From: Simon Davis
Sent: 01 July 2021 12:29
To: 'Lauren Wiltshire' [REDACTED]
Subject: RE: Fontwell Avenue, Eastergate

Condition Refusal Issued 29/06

Forthcoming Condition Refusals to be issued today/tomorrow

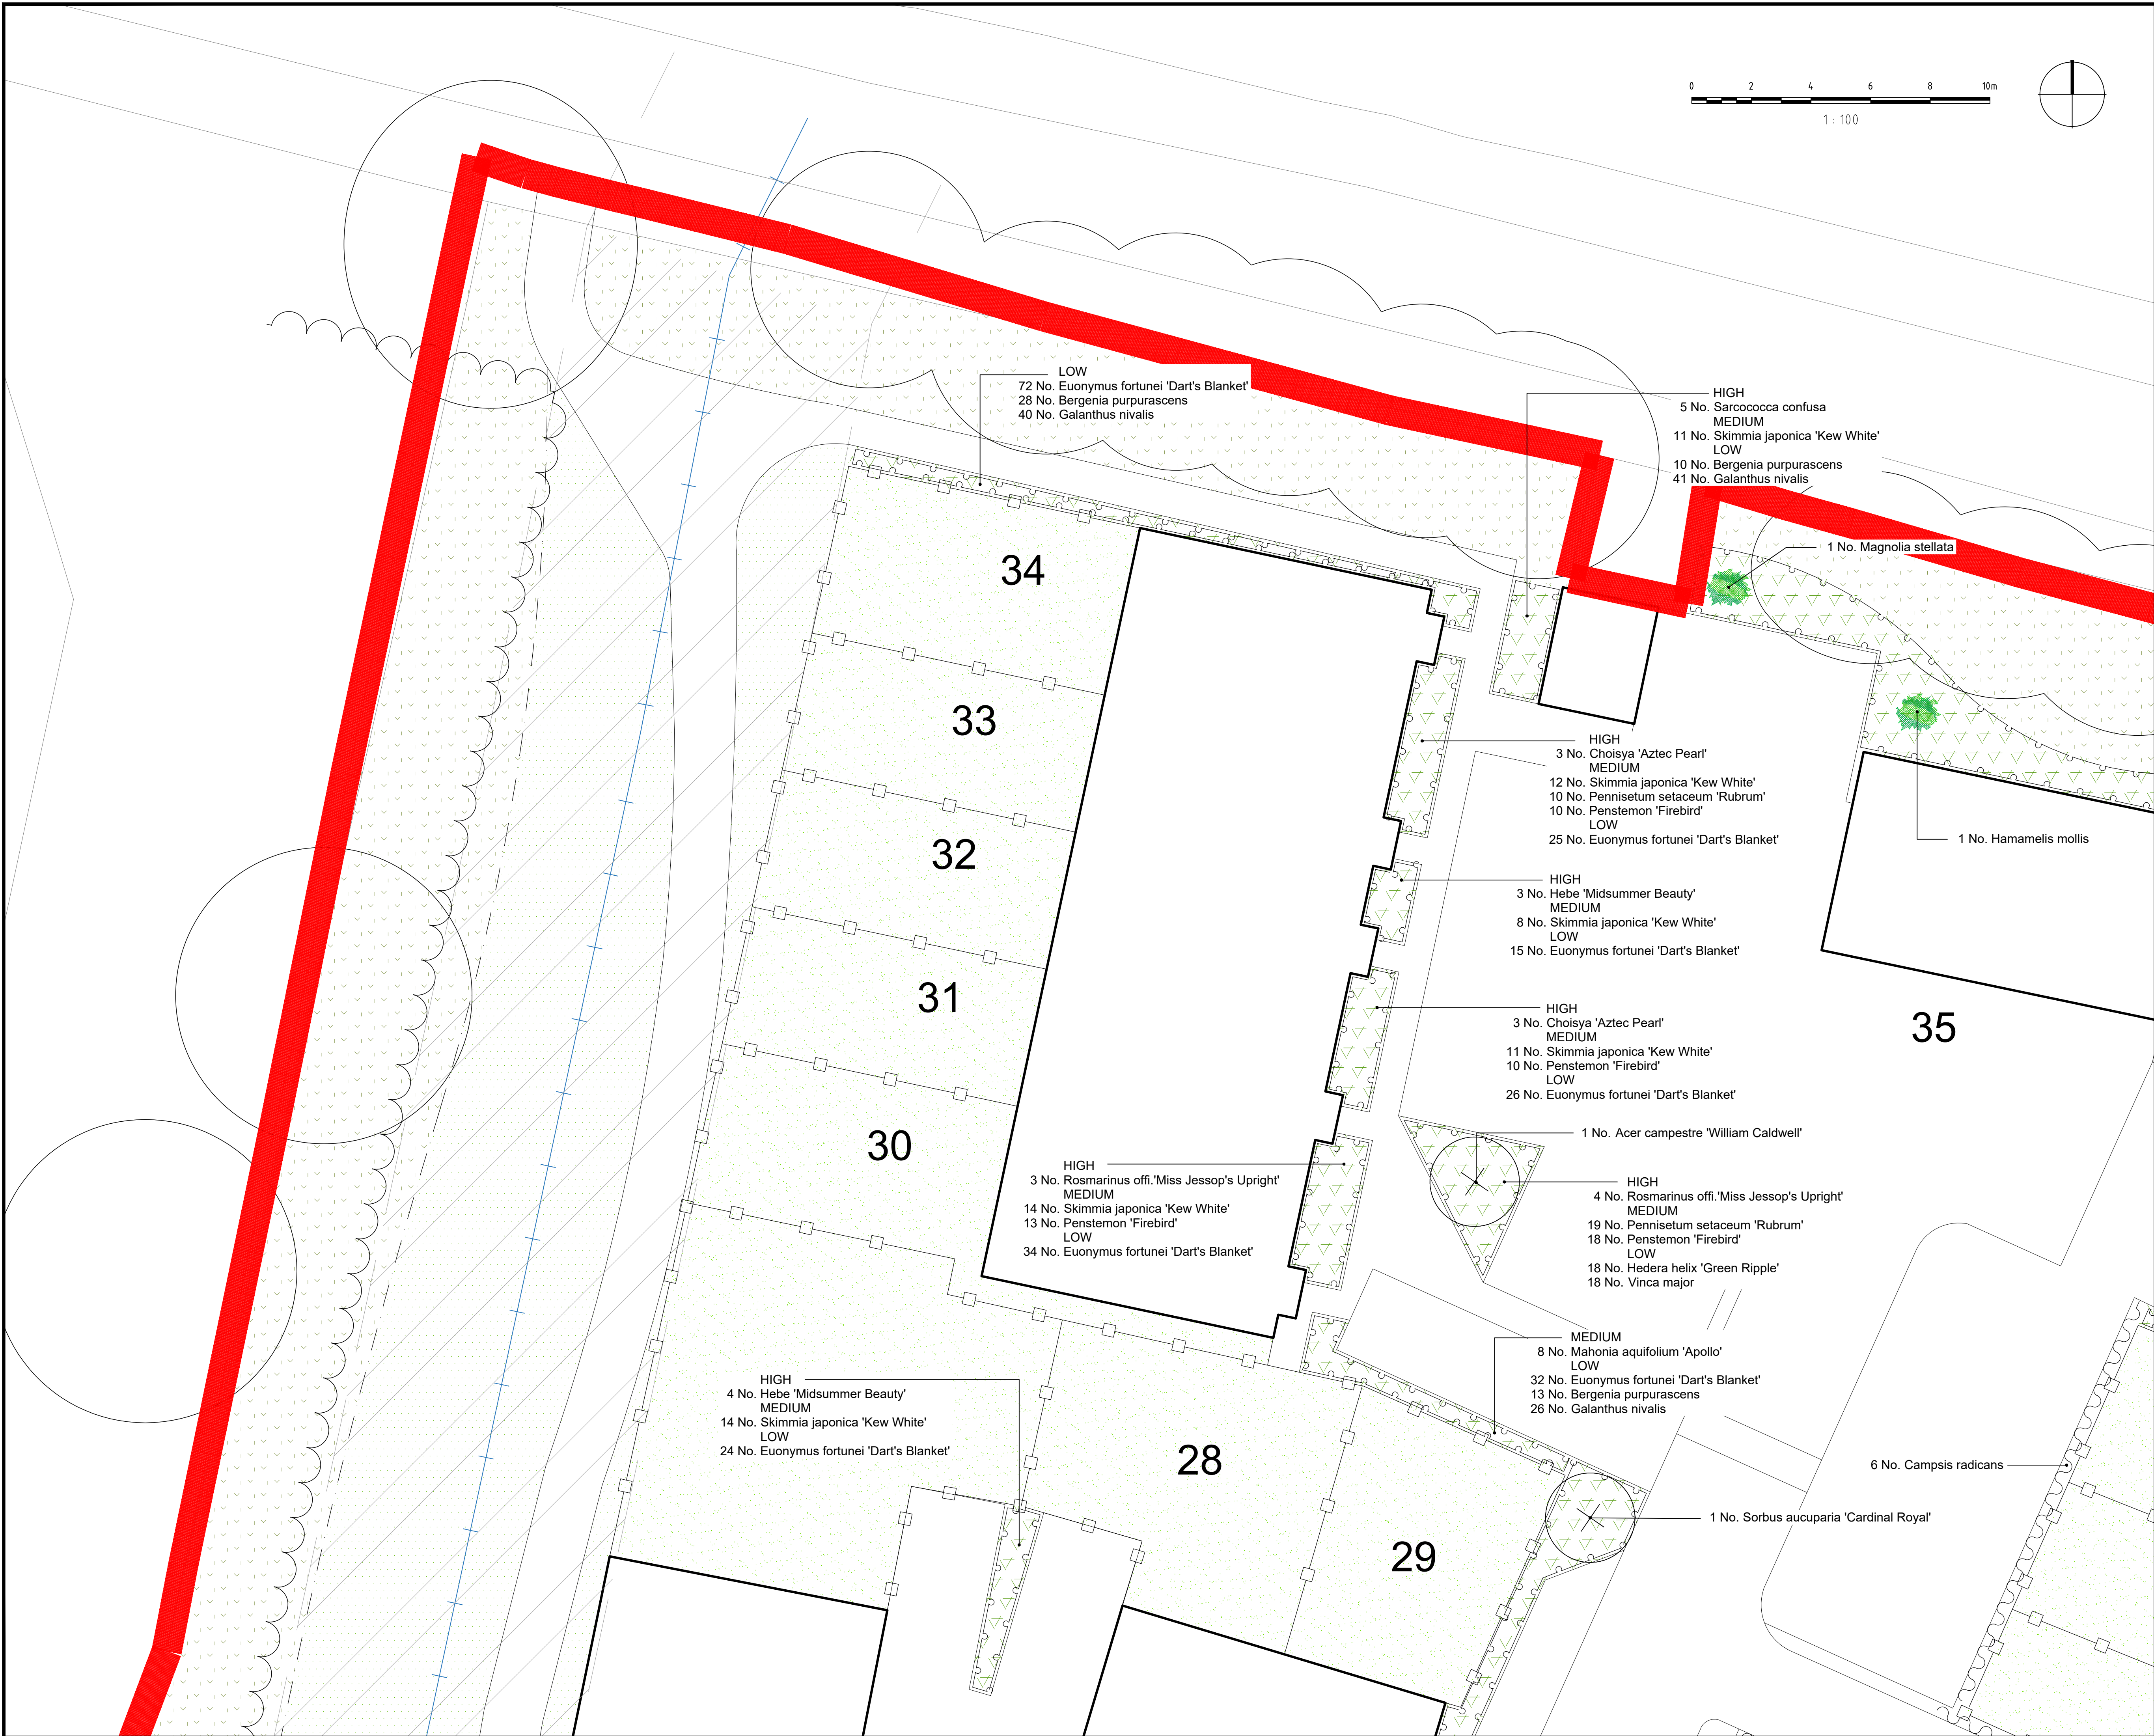
17 – Our Landscape Officer, Sue Howell requested that the play area details be shown on the drawings. Her comments were sent to you on 07/06/21. However, it was I who picked up on the fact that the non-standard requirements of the condition (26 new native trees inc large specimens) had not been clearly addressed.
